ENG-CDR21013-R4-FDR.pdf Markup Summary

Fig. 1

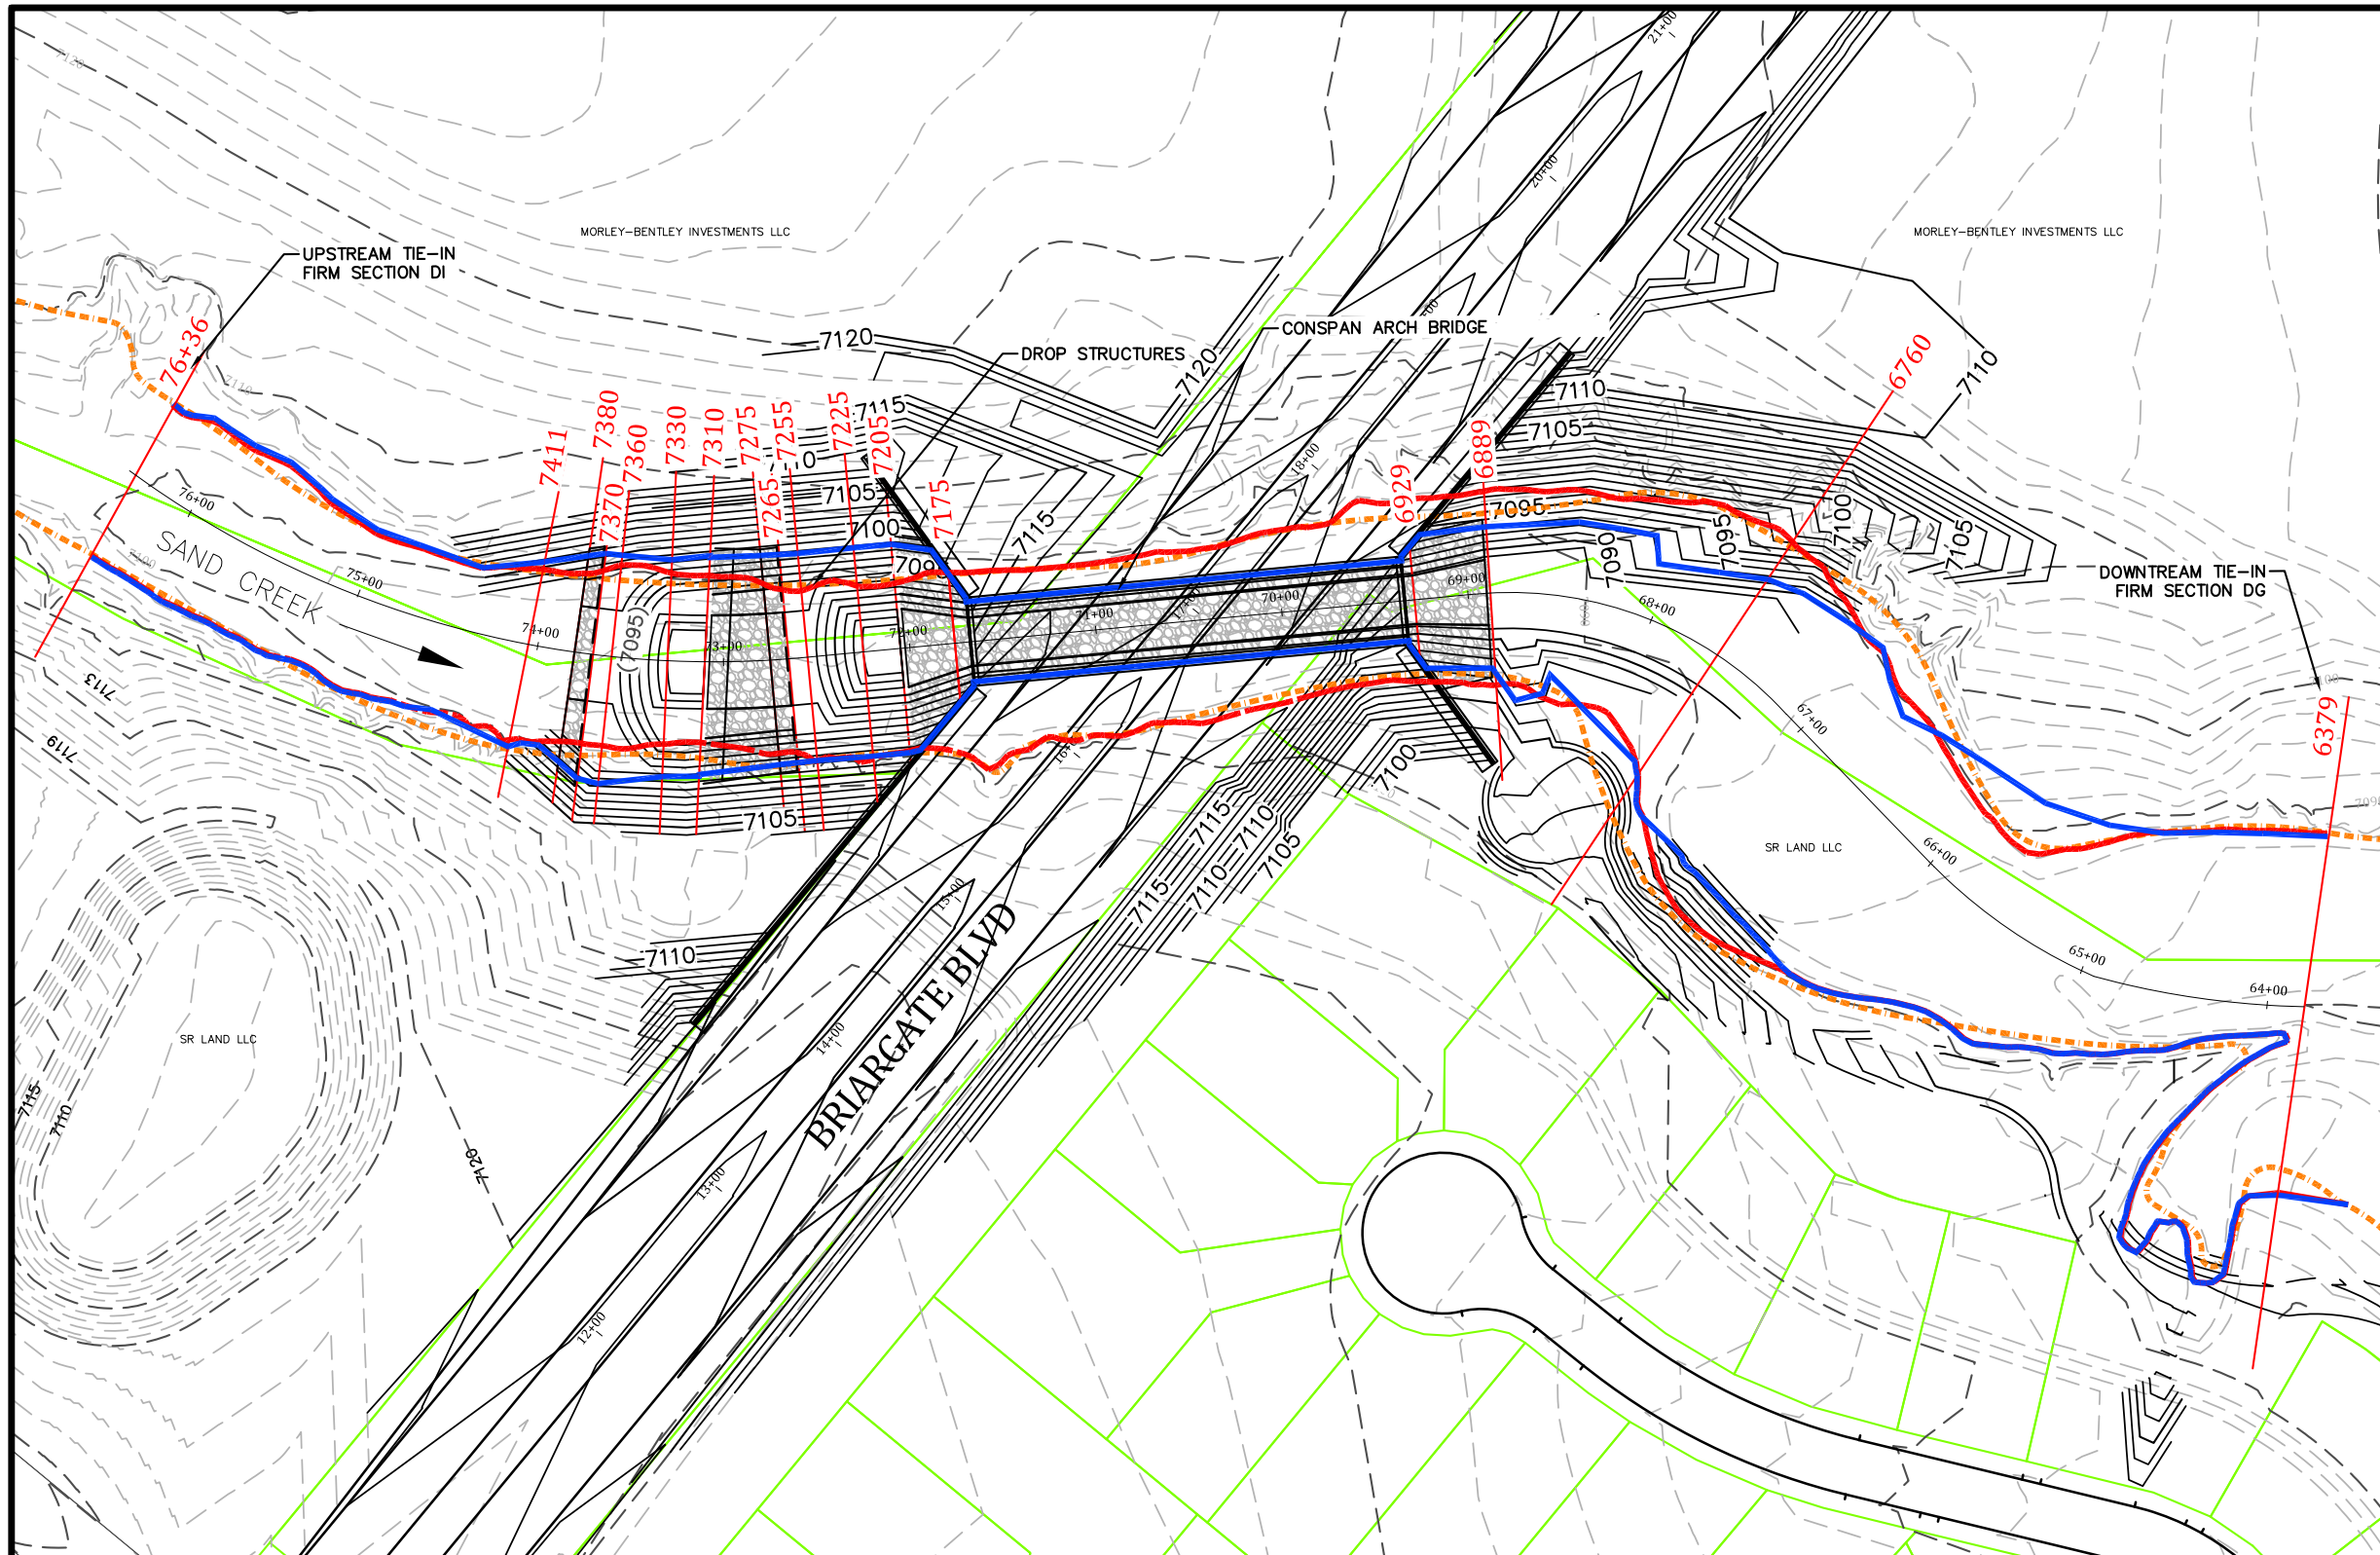
Wrong project
